**Planning & Building Control Service
Development Management
Westgate Plaza
PO Box 603, Barnsley, S70 9FE**

Our ref 2022/0916 & 2025/ENQ/00760
Date: 09/01/2026
Enquiries Elaine Ward
Direct Dial: 01226 774731
Email: elaineward@barnsley.gov.uk

APPLICATION FOR NON-MATERIAL AMENDMENT to planning application 2022/0916 Development of 2no warehouses (floorspace of 9,755m2 and 7,804m2) for general industrial and storage and distribution purposes (use classes B2 and B8) with provision of ancillary office accommodation (Reserved matters of the outline part of hybrid planning permission 2019/0286 seeking approval of external appearance, landscaping, layout and scale) (Amended Plans)

Higham Lane, Dodworth, Barnsley, S75 3UB

Masterplan 1:1250

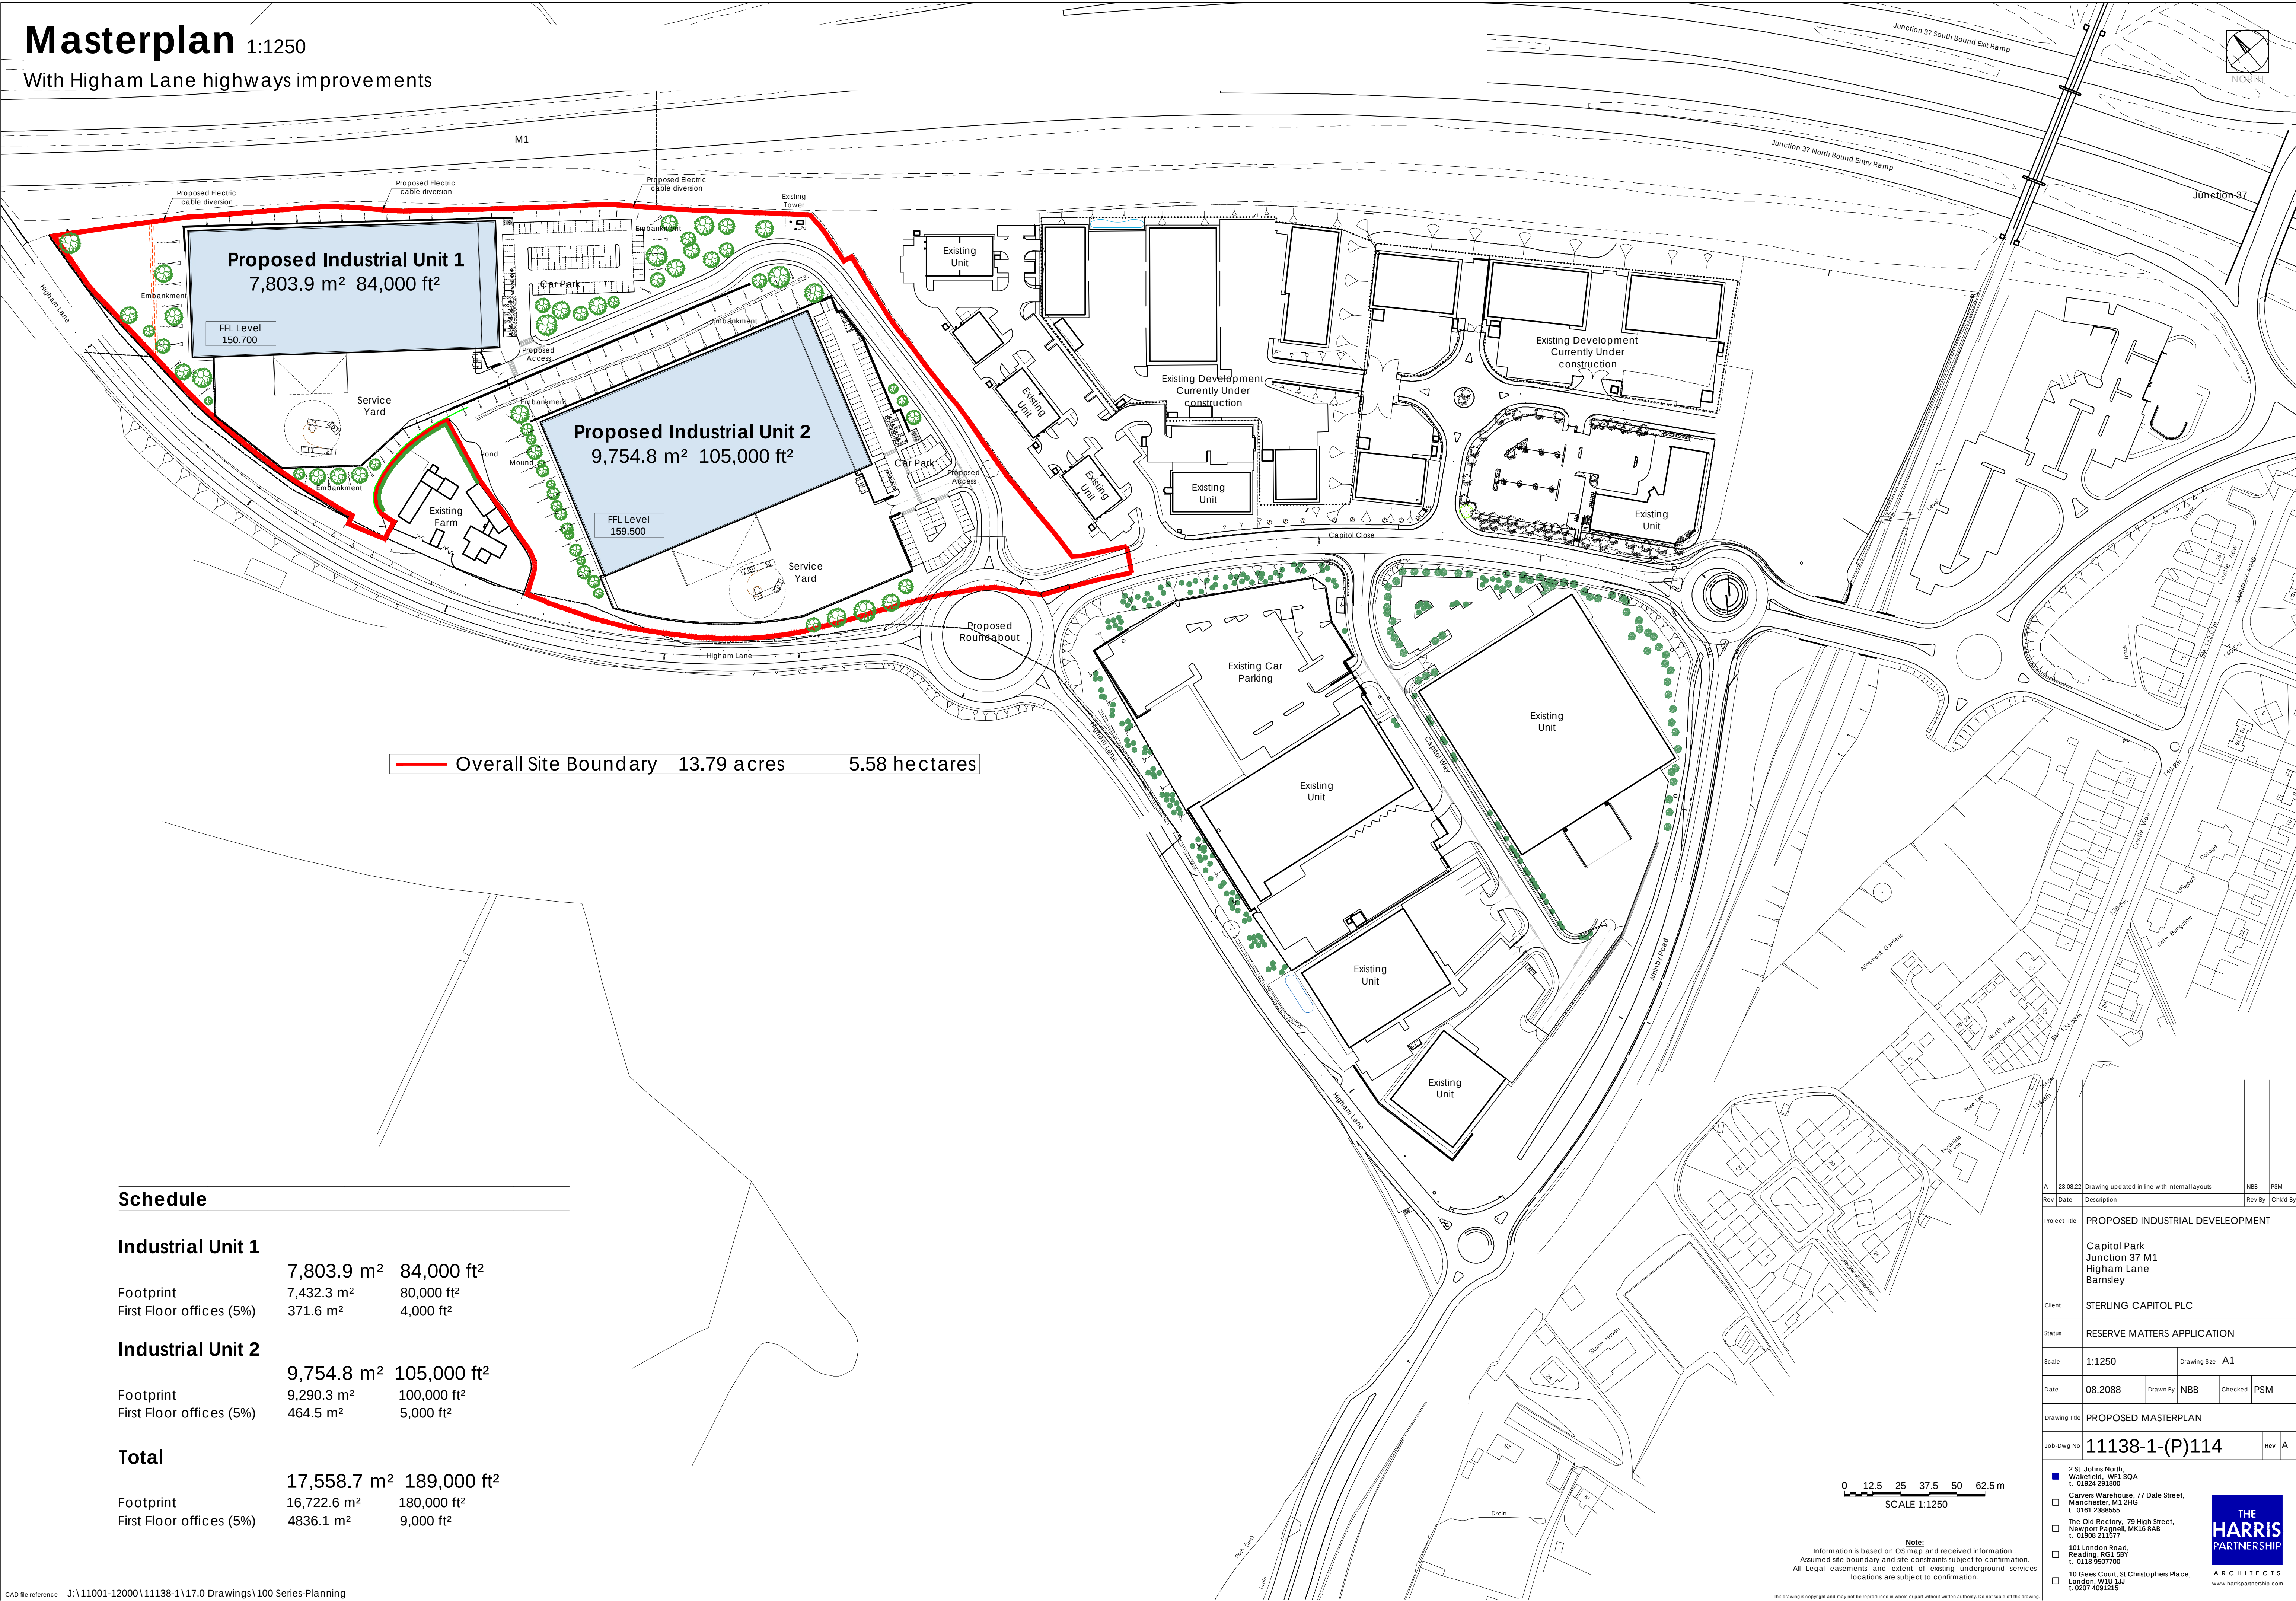
The revised plans for the non material amendment show a straightened access road following the right-hand turn into the site from Capitol Close. All other aspects of the development remain unchanged.

11138-1(P)110 Proposed Masterplan REV G
11138-1(P)111 Proposed Site Plan REV G
11138-1(P)113 Proposed Sections REV A
11138-1(P)115 Proposed Site Plan REV H
11138-1(P)117 Proposed Unit 2 Site Plan REV G
3533-100-SK-1001 REV D to be replaced by 4173-JPG-DR-C-1655-S2-P09
